Appeal Decision

Appeal Reference: APP/R5510/W/25/3360554

5 Crossway, Hayes, Hillingdon UB3 3JG

- The appeal is made under section 78 of the Town and Country Planning Act 1990 (as amended) against a refusal to grant planning permission.
- The appeal is made by Mr. P. Patel against the decision of the Council of the London Borough of Hillingdon.
- The application reference is 20650/APP/2024/1895.
- The development proposed is described in the application form as “Change of use from Single Dwelling (C3) to Class (C4) 6-Bed HMO”.

## Existing First Floor Plan

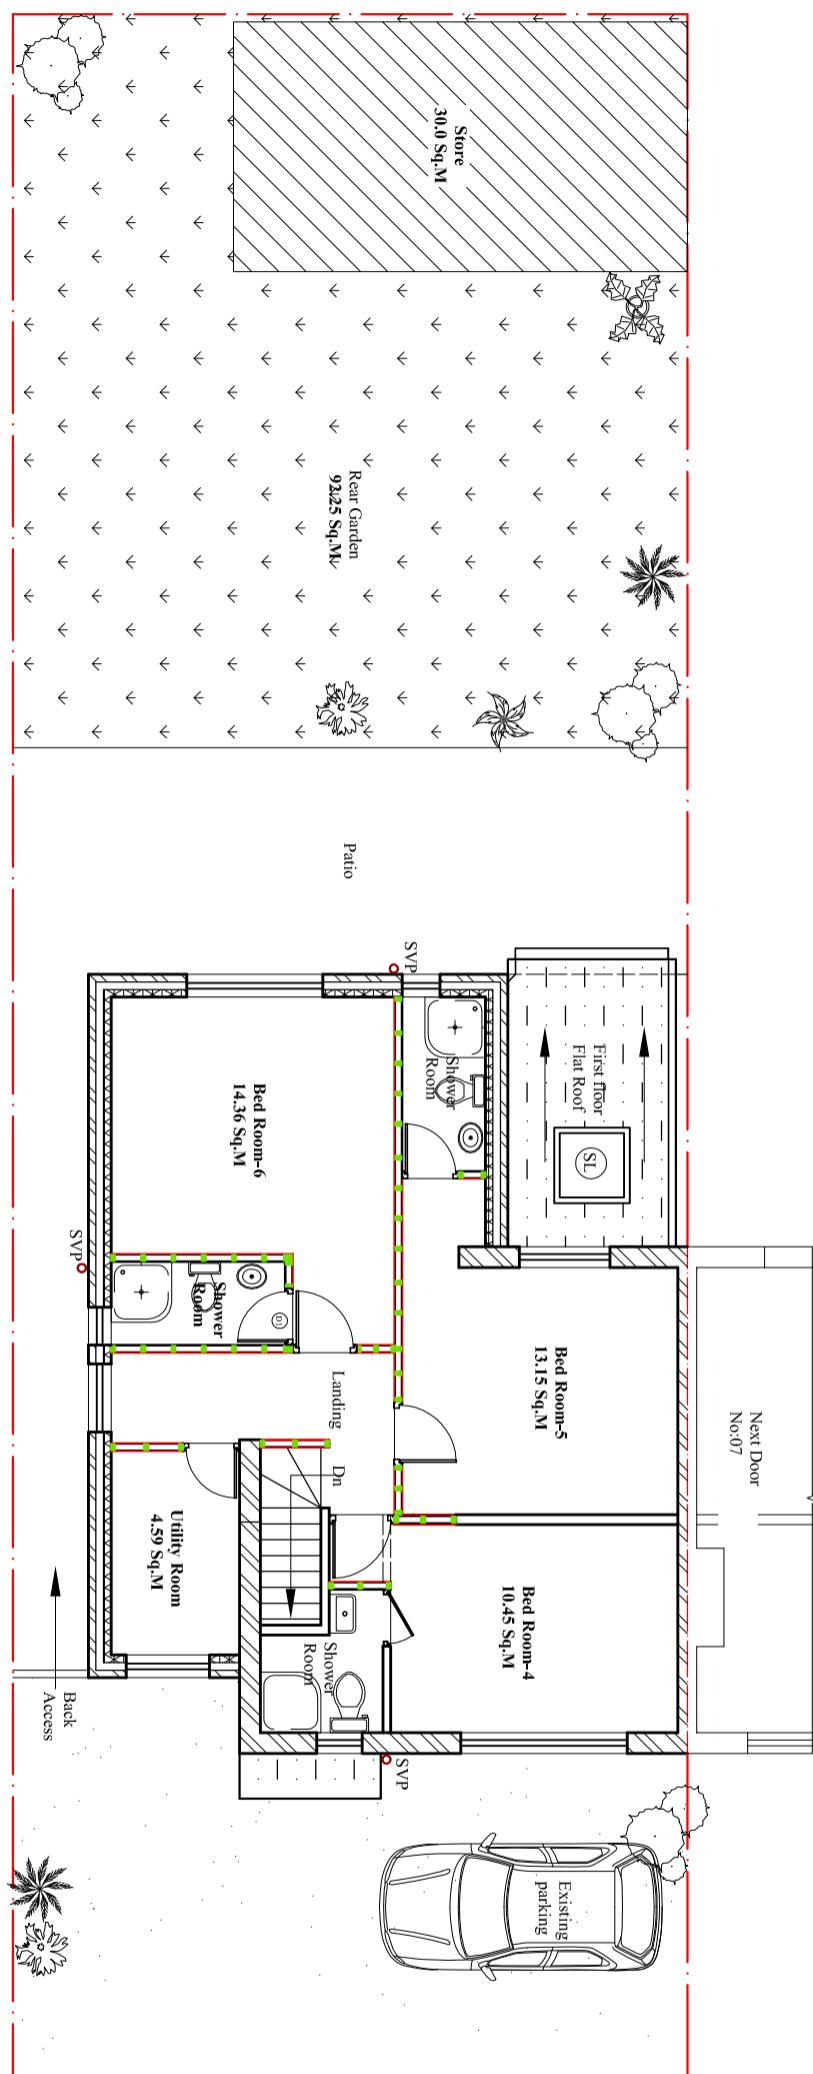
8. The outbuilding is described as a “store” and appears to be available to occupiers as a shared space. There is a shared “kitchen lounge” and a shared bathroom on the ground floor within the main building, while the individual bedrooms in various parts of the house are each provided with their own shower rooms. There is a small sitting room on the first floor (marked on the “existing first floor plan” as a “utility room”) but this does not appear to be accessible to all residents.

Client: Mr/S. Pushkar Patel.	
Project: Change of use from Single Dwellings (C3) to Class (C4) 6-Bed HMO.	
Location: 5 Crossway, Hayes, Middlesex, UB3 3JG, London.	
Status: PLANNING	
Title: Proposed Front parking plan

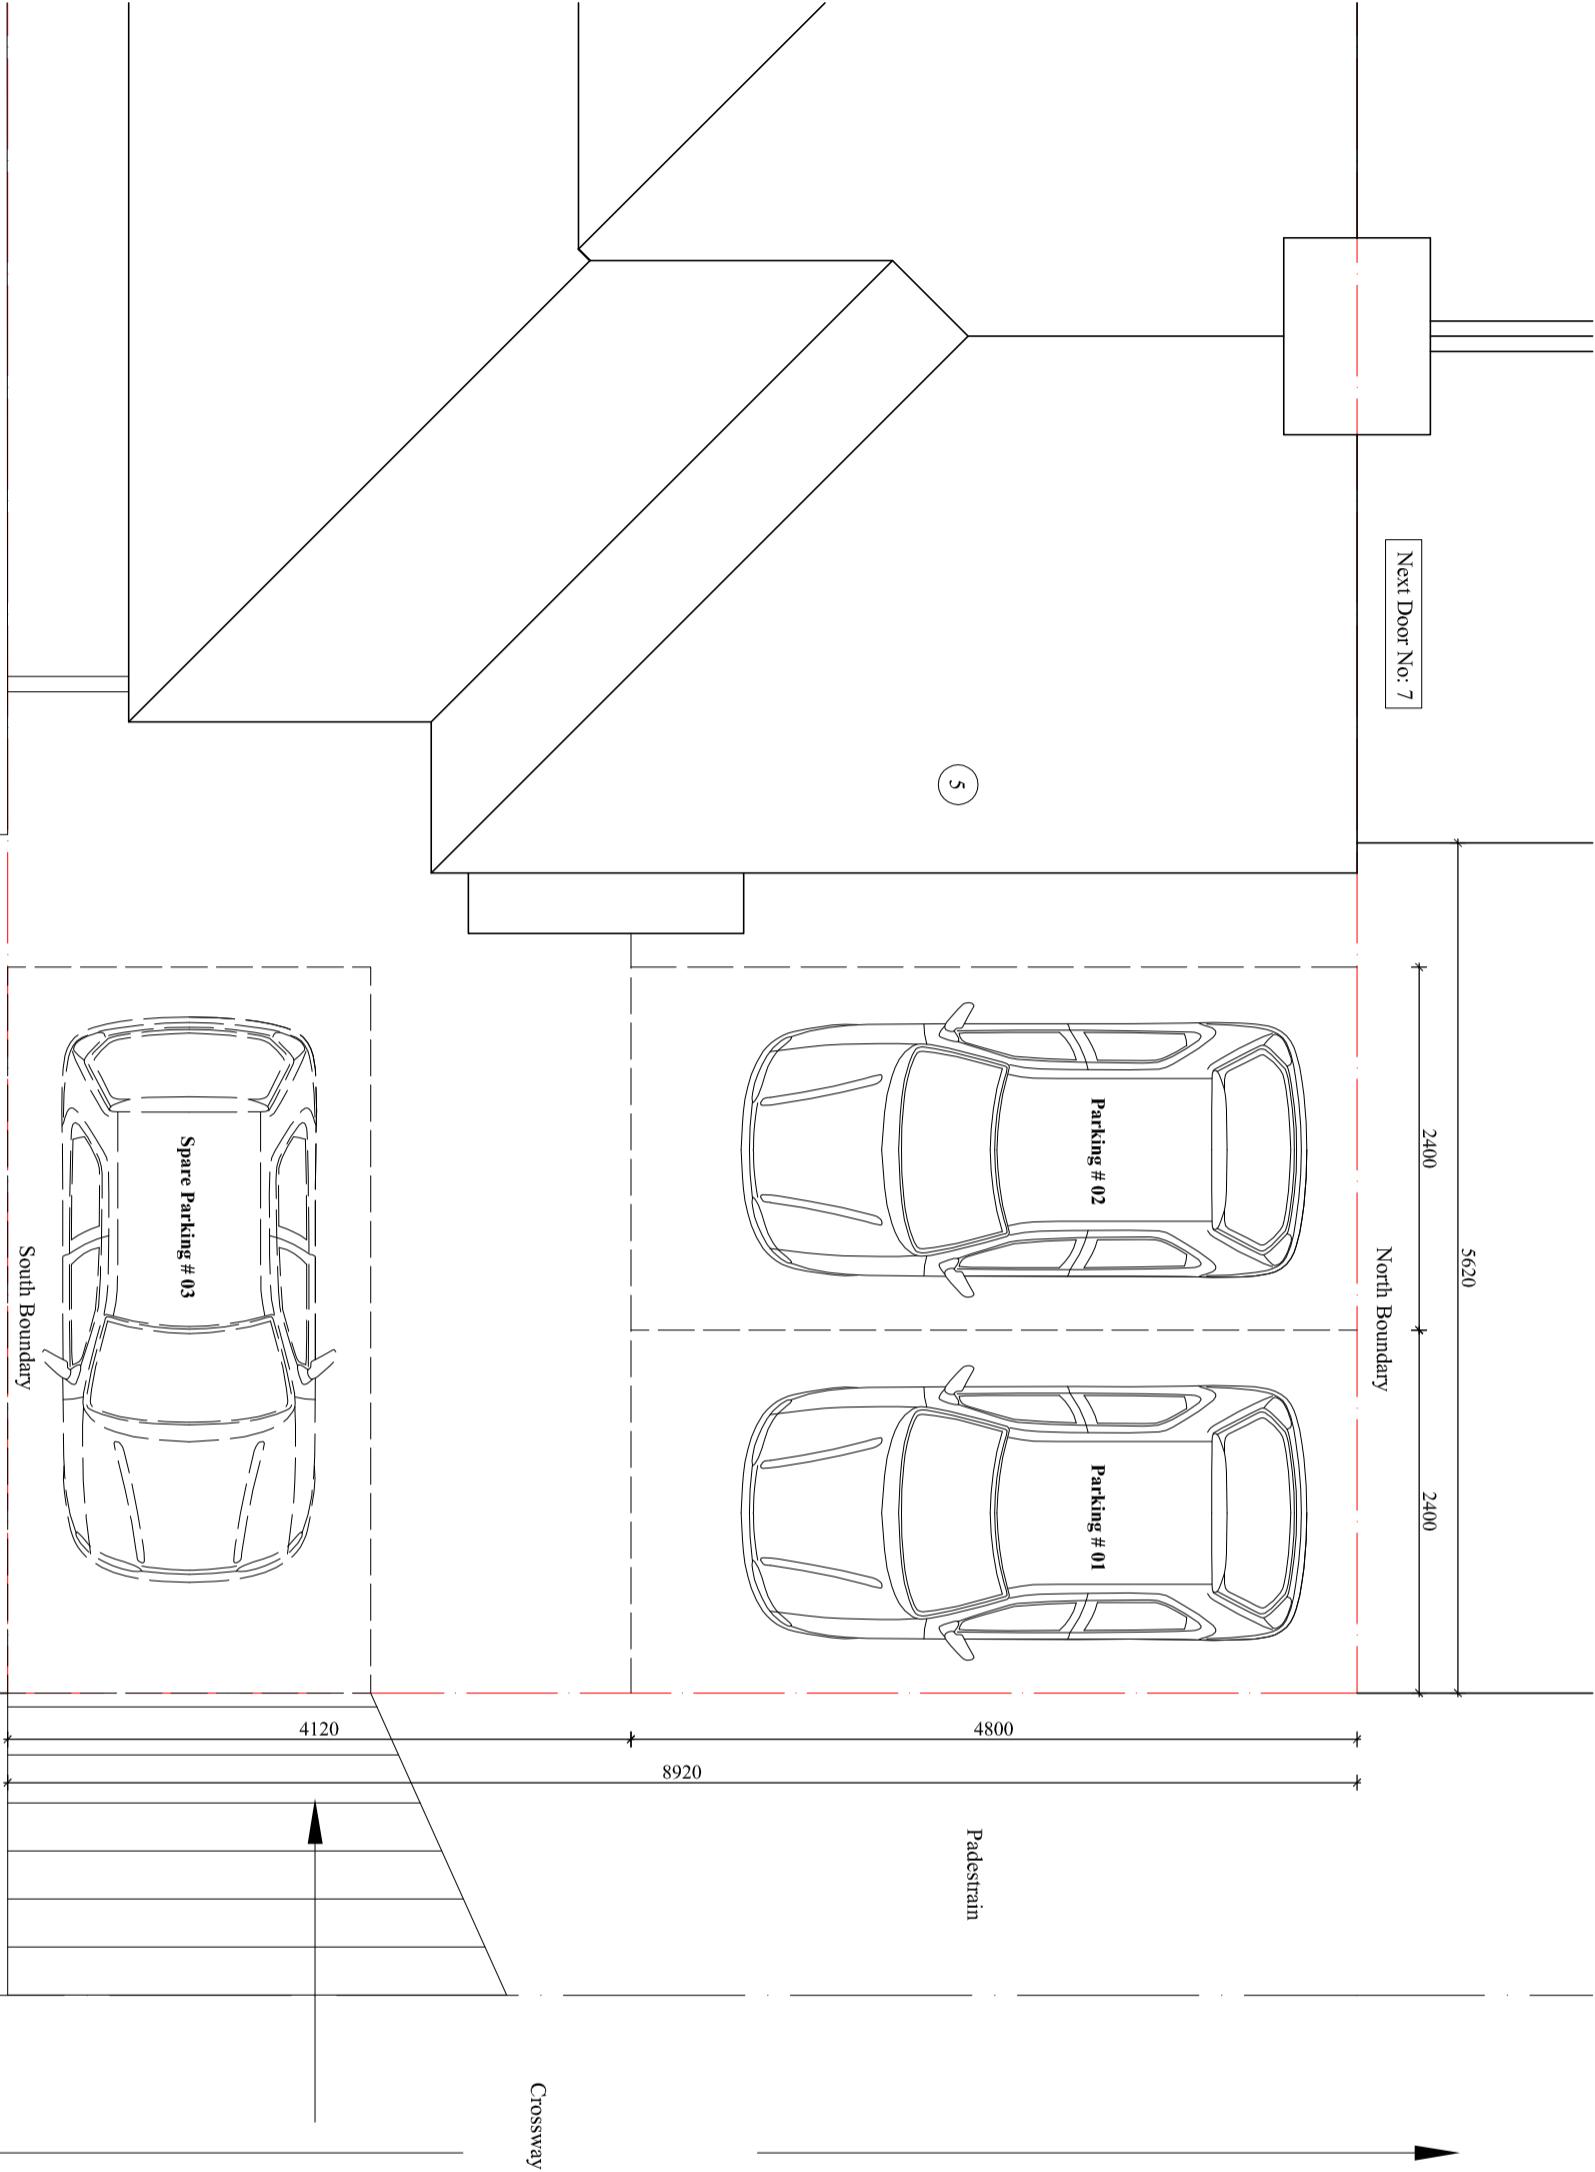
15. In reaching that conclusion, I am conscious that the physical appearance of the appeal building would not be materially changed. The proposed parking layout for the front garden area would be more intrusive, although the front boundary was not marked by a wall at the time of the site visit. The status of the front boundary wall is unclear, however, and I cannot attach real significance to the “loss of the front low boundary brick wall” that is criticised in the Council’s reasons for refusal, even though the open frontage, as it currently exists, clearly detracts from the appearance of the Area of Special Local Character.

19. The forecourt of the property can realistically accommodate only two car spaces, and the lack of adequate parking also justifies the refusal of planning permission in this case. Even so, the paving of the entire frontage of the property creates a hard and unattractive appearance, which detracts from the visual qualities of the surroundings.
